ABP-320705-24 (Knockshanvo Wind Farm & 110kV Substation)

VA03.320727 / ABP-317763 (110kV Grid Connection & Subsurface Cabling)

Date: 4th August 2026

We are writing to submit a formal observation directly responding to the planning statements and response to observations submitted by the applicant, FuturEnergy Knockshanvo DAC (prepared by MKO).

CLIENT

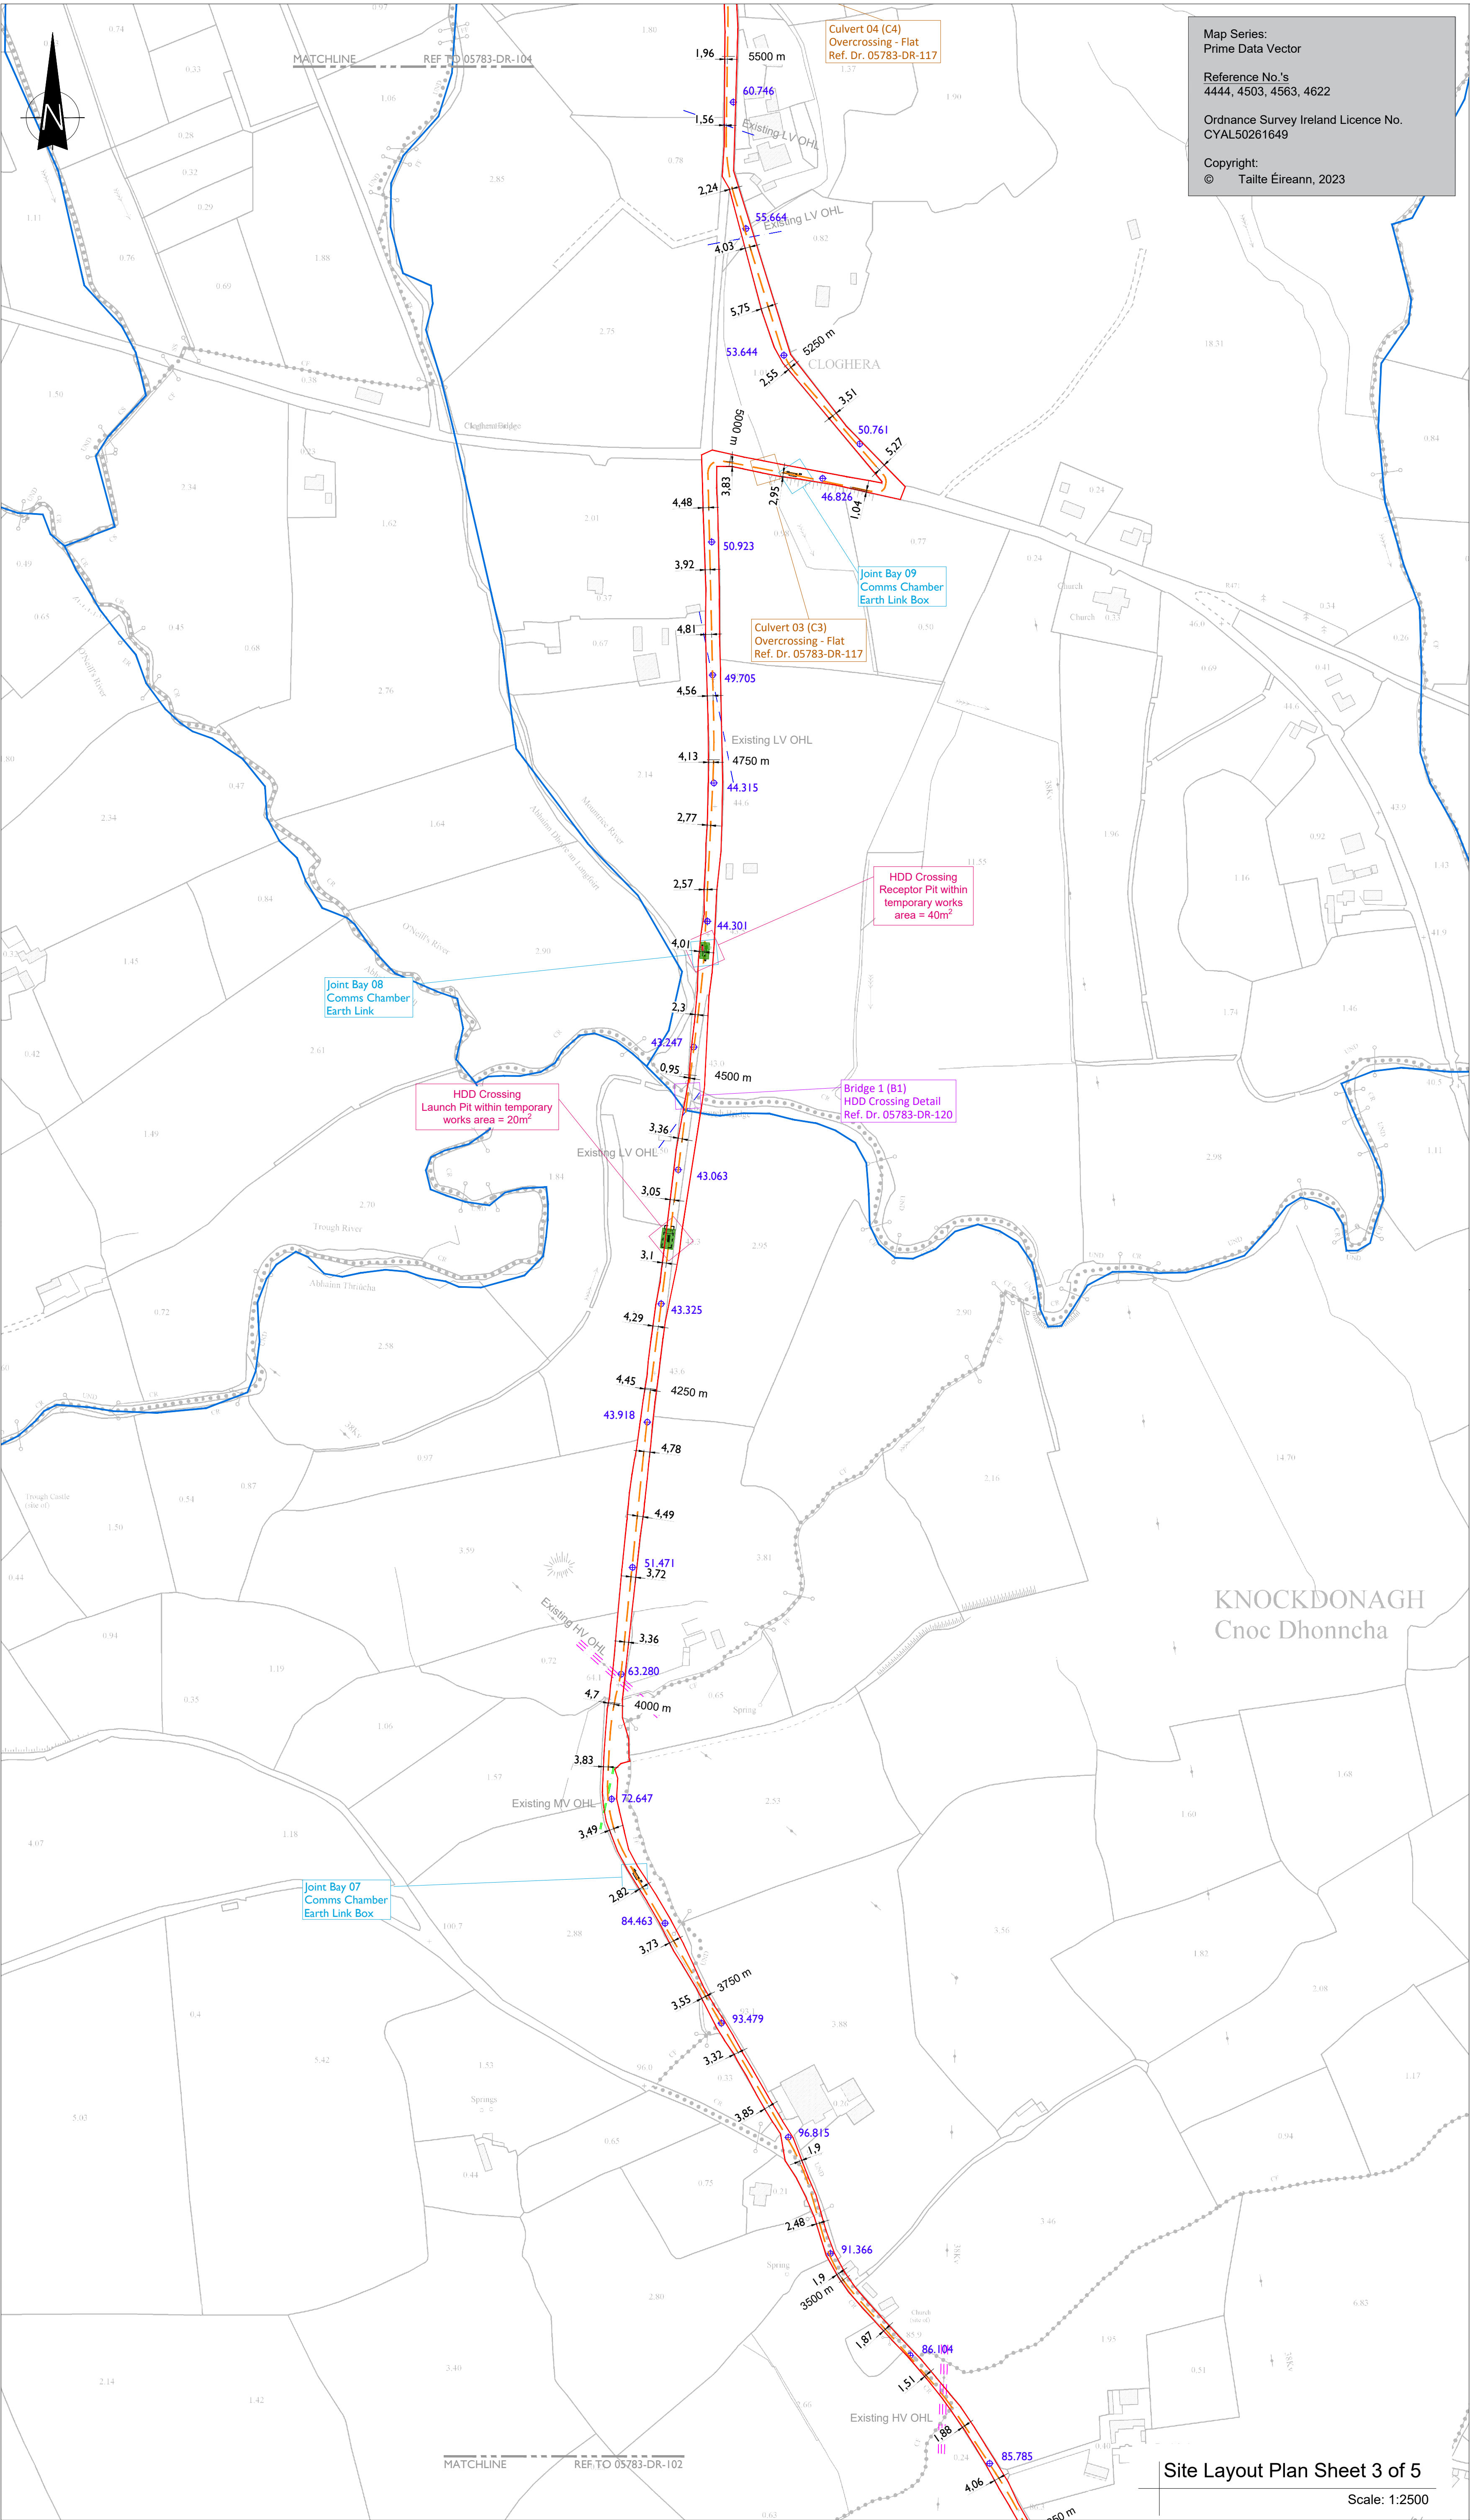
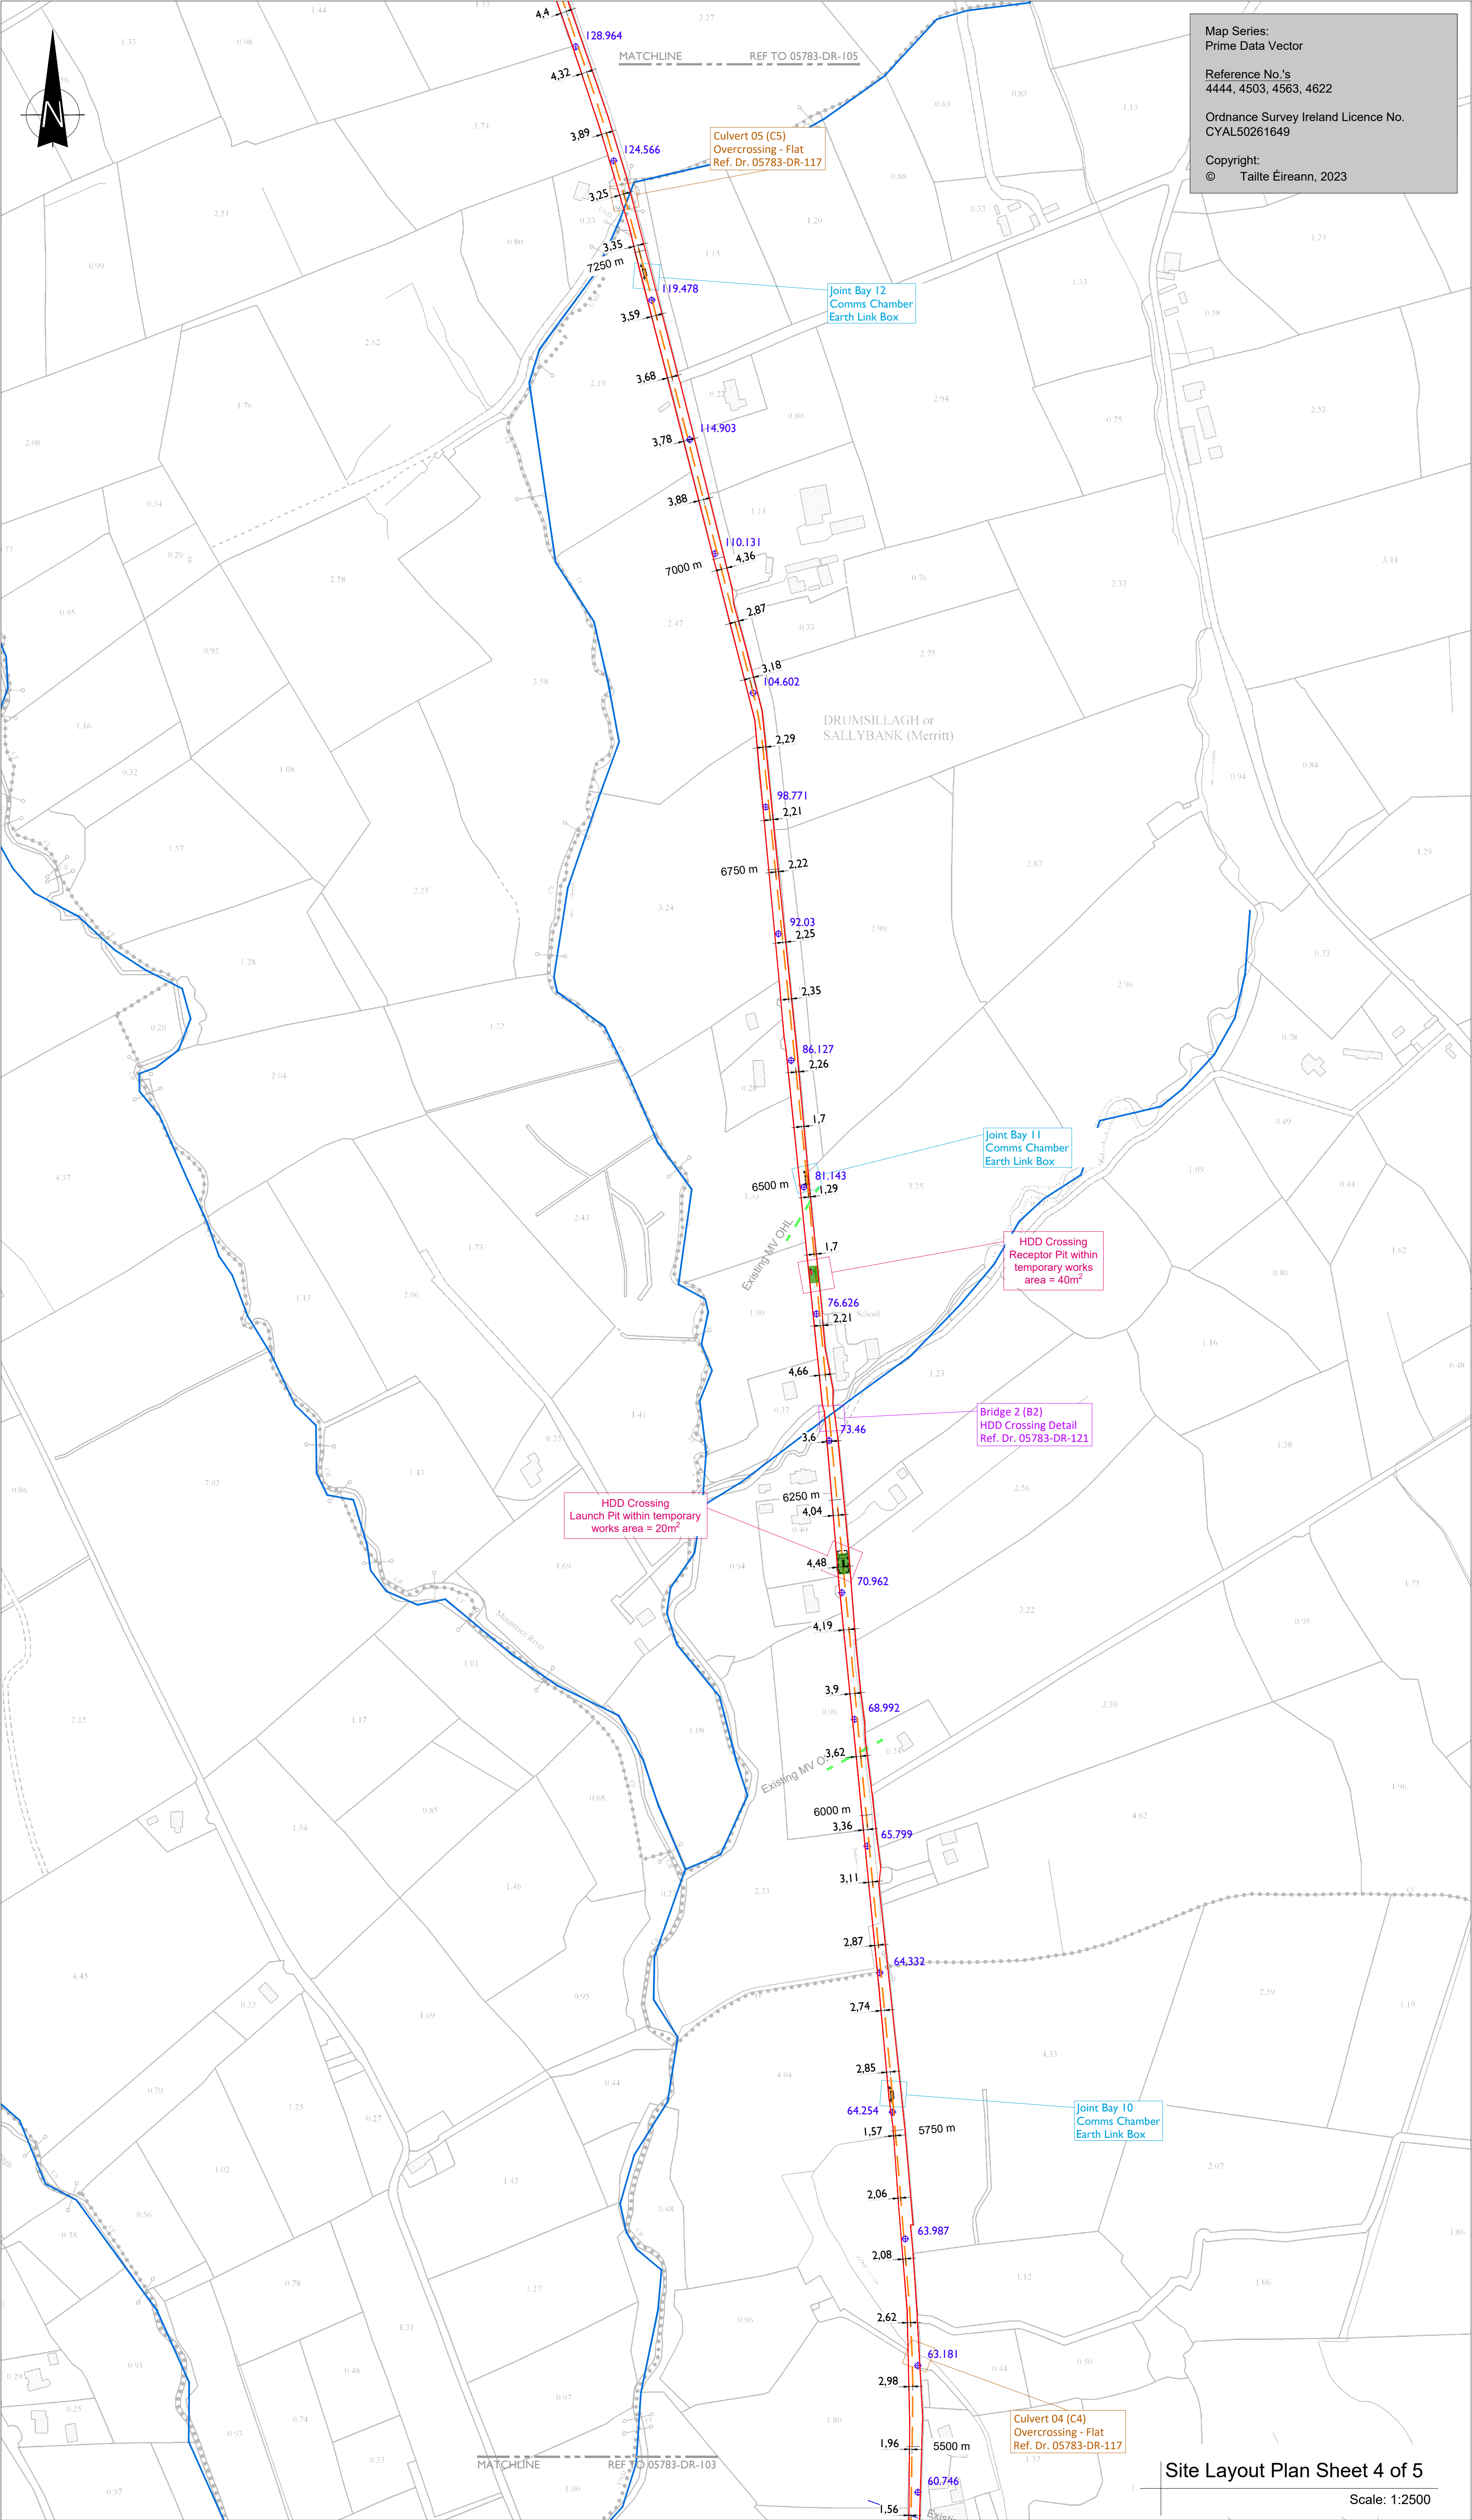
As the side wall of our house forms the direct boundary line flush with Sallybank Road, heavy industrial rock-breaking, excavation, and deep trenching will occur in very close proximity to our home's primary load-bearing walls.

While MKO promises to restore the public road tarmac for Clare County Council, they have provided zero localized structural engineering assessments, zero baseline structural surveys, no vibration monitoring protocols, and no structural indemnity framework to protect our home against catastrophic cracking or subsidence.

Sallybank Road (L3042) is a highly constrained, narrow country lane where two passenger cars cannot consistently pass. Digging an open high-voltage trench while operating heavy industrial plant machinery will physically consume the entire road width outside our gate. The developer has provided no engineering methodology proving how a passable lane can be physically maintained. This layout cuts off our right of way, trapping us inside our property or barring access home, particularly when works are ongoing outside of our property.

Furthermore, as raised in our original submission, we reject the applicant's unfounded assertion that subsurface cable trenching along Sallybank Road (L3042) will progress seamlessly at 100 meters per day to complete in "one month". The applicant's response document provides zero technical or engineering methodology to substantiate this rate of progress along a narrow, constrained country lane. Given that our property sits 3 km along this single-lane corridor, the developer's reliance on generalized post-consent Traffic Management Plans (TMPs) fails to address real-world construction delays, physical road blockades, or how daily residential and emergency access will be physically guaranteed over what will inevitably be a far more prolonged and disruptive timeframe.
